Date: 22 November 2019

Application by ScottishPower Renewables for an Order Granting Development Consent for the East Anglia TWO Offshore Wind Farm

Advice following issue of decision to accept the application for examination

01/03/2021

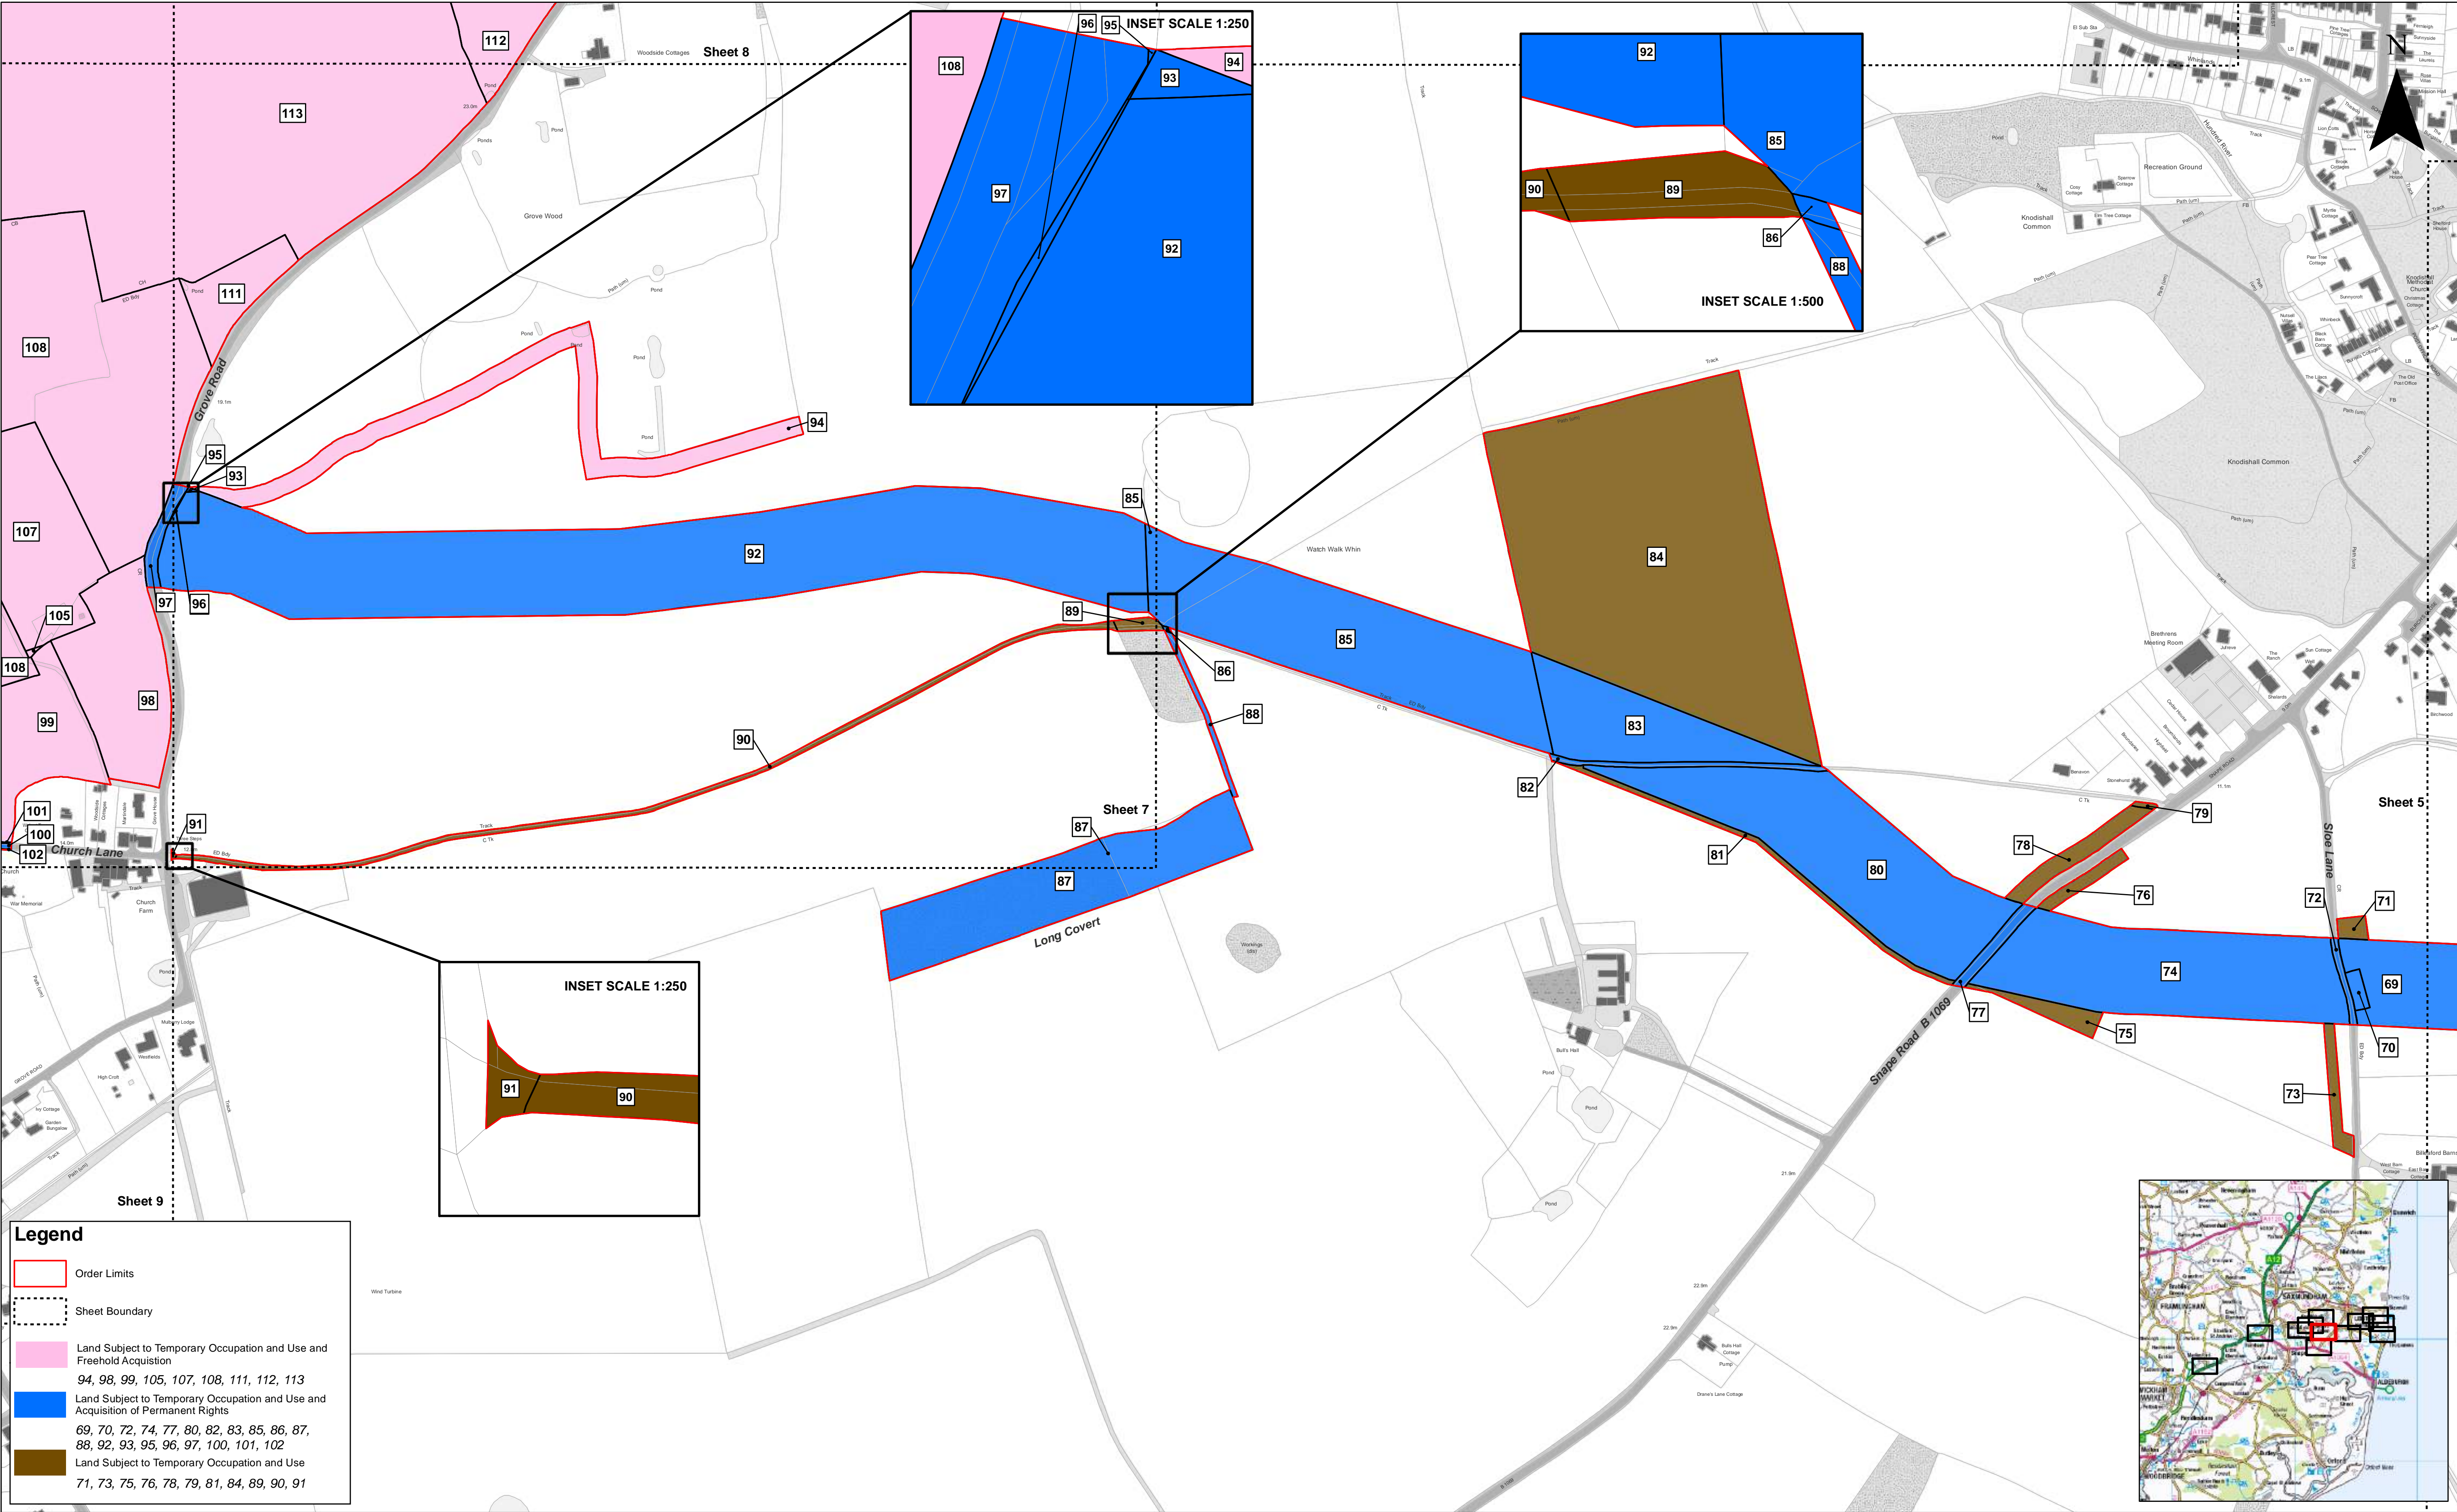
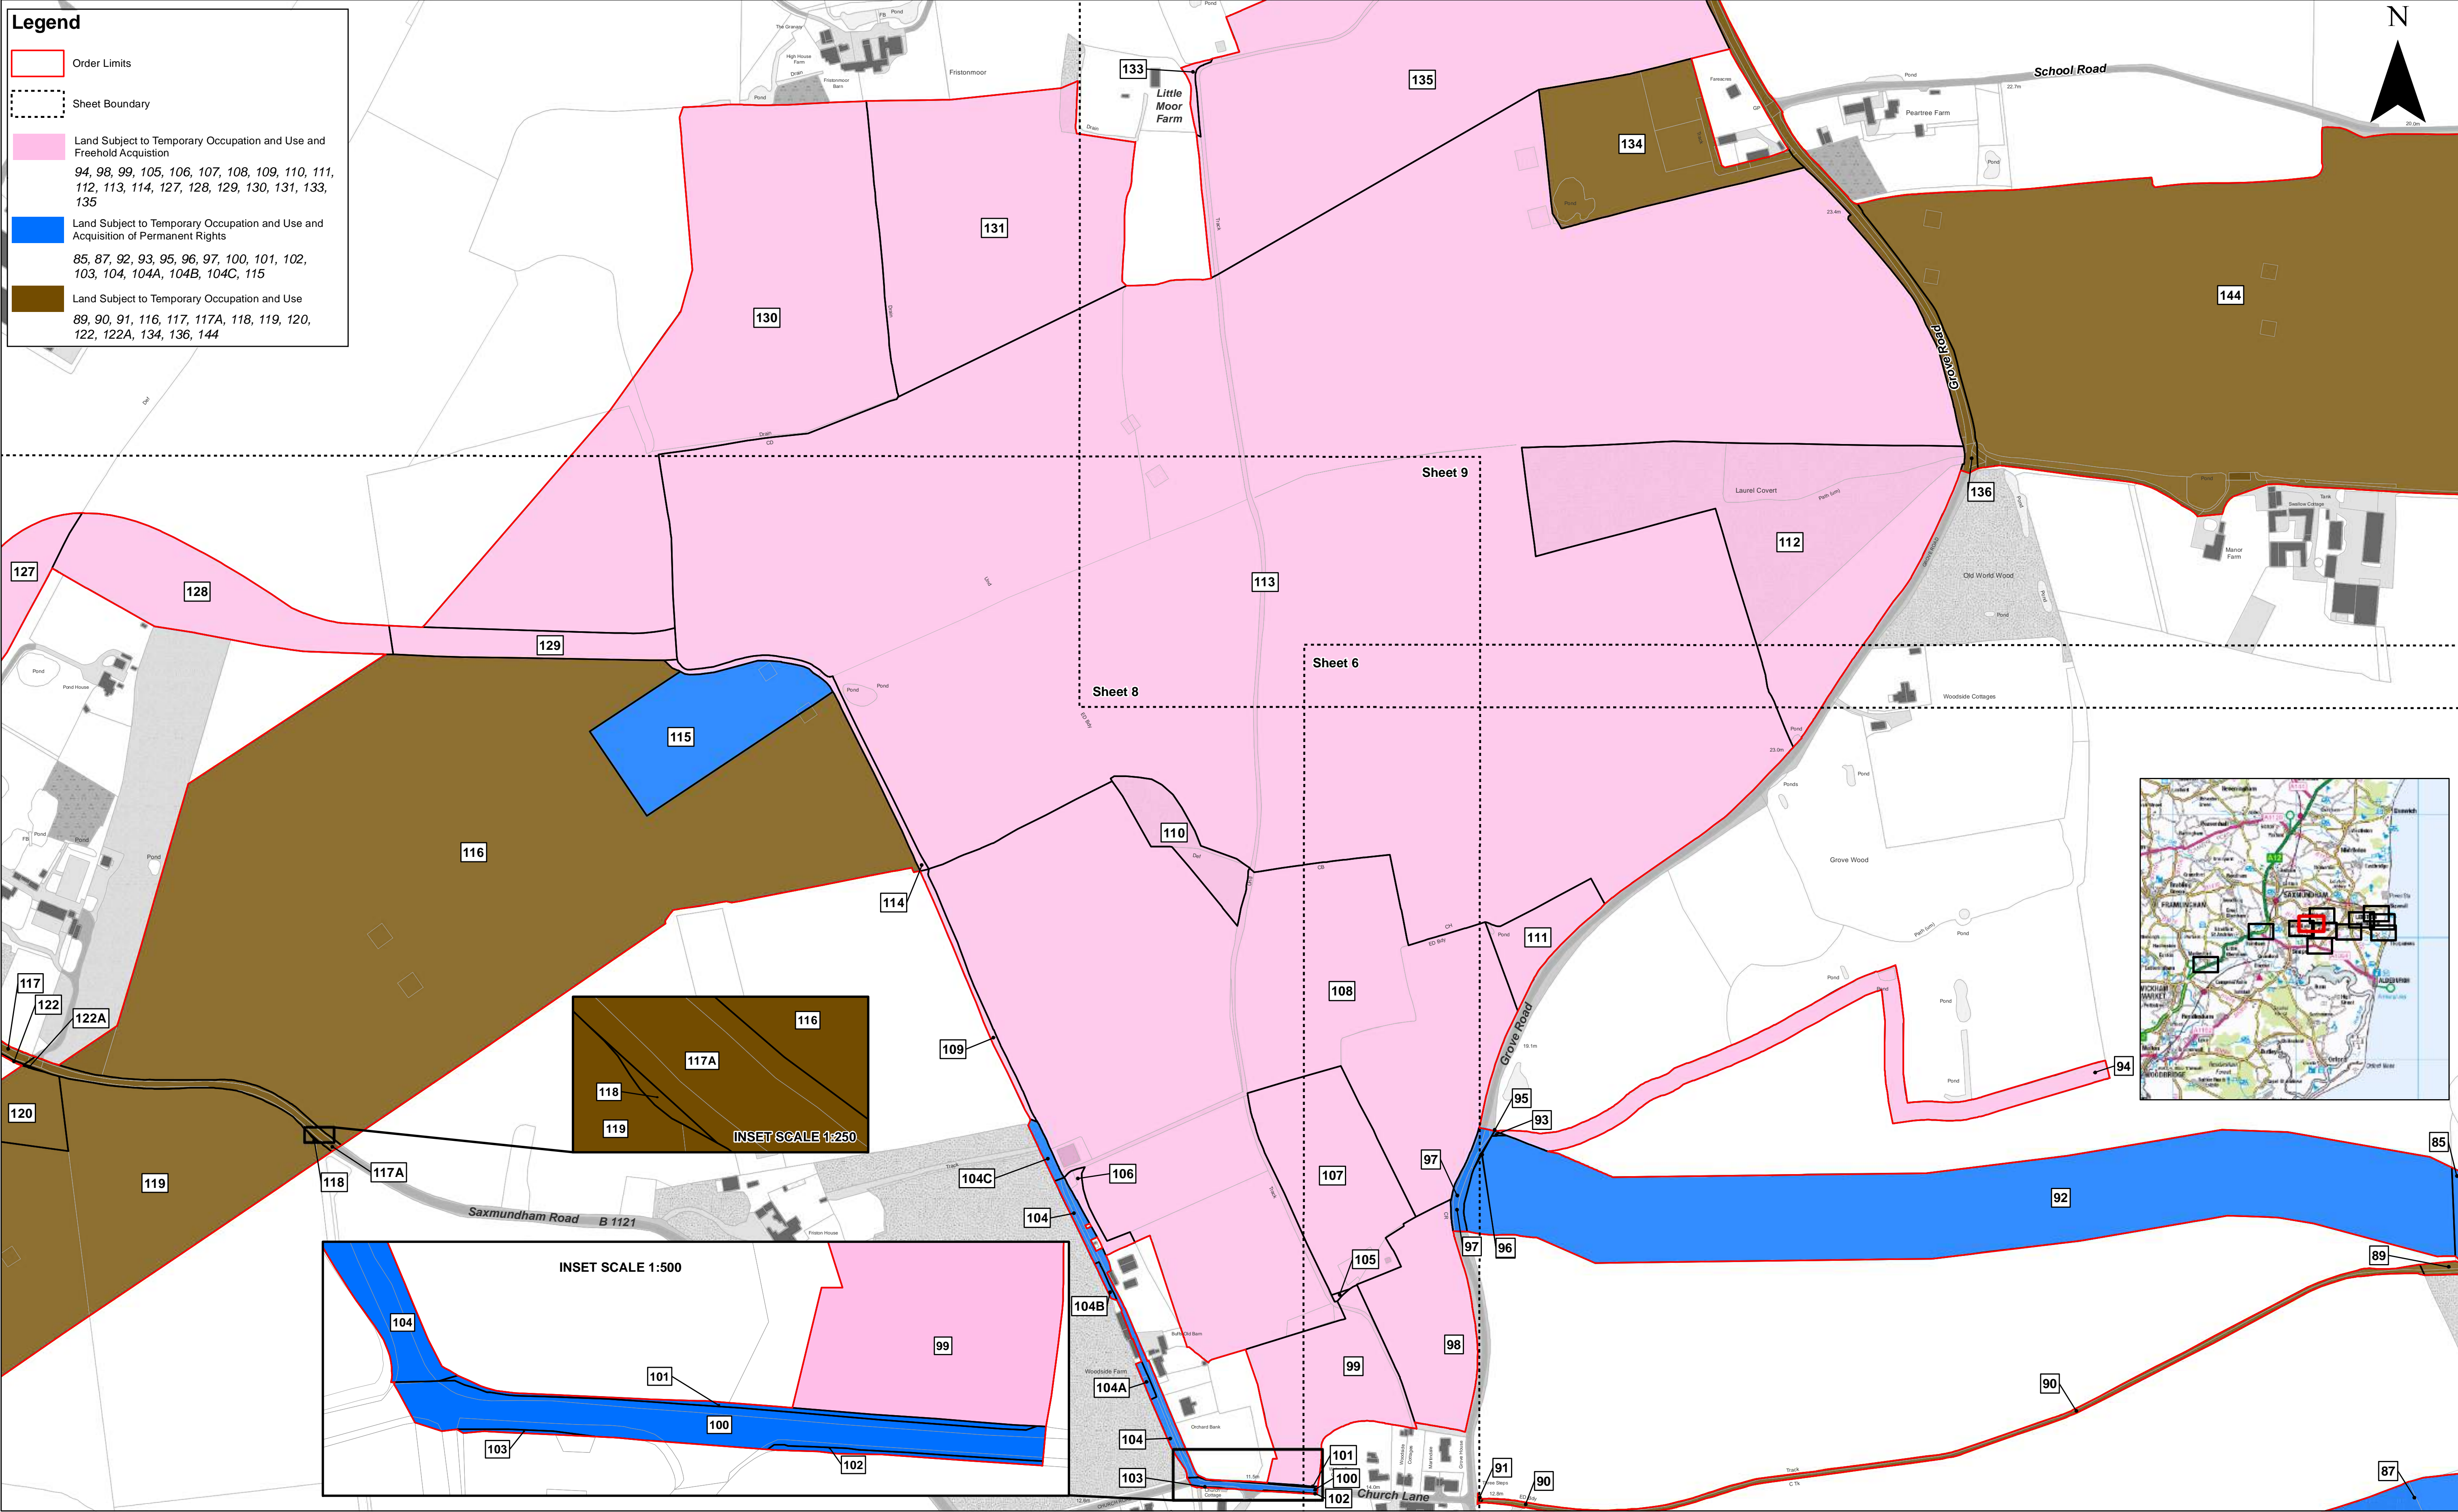
Please provide updated Land Plans which include:

- The names of all relevant landmarks described in Column 2 ('Extent of acquisition or use') of the BoR (e.g. Sizewell Estate, Sizewell Gap, Grimsey's Lane, Blackheath Estate, Redhouse Farm and Knodishall Hall) should also be shown on the relevant Sheets of the Land Plans.

- Road names on the Land Plans to assist the identification of land should be shown more clearly.
- Larger and clearer landmarks on the relevant Sheets of the Land Plans.

- The same map base as the other submitted plans and sheet layout. (It was noted in the checklist that the Land Plans have used a different map base to the other submitted plans, and this makes comparison between the Land Plans and the other submitted plans more difficult than it needs to be.)

- Additional insets. (It was noted in the checklist that Plots 18, 91 and 126 would benefit from being shown on an inset plan.)
- Corrected Plot number for inset 9.4.
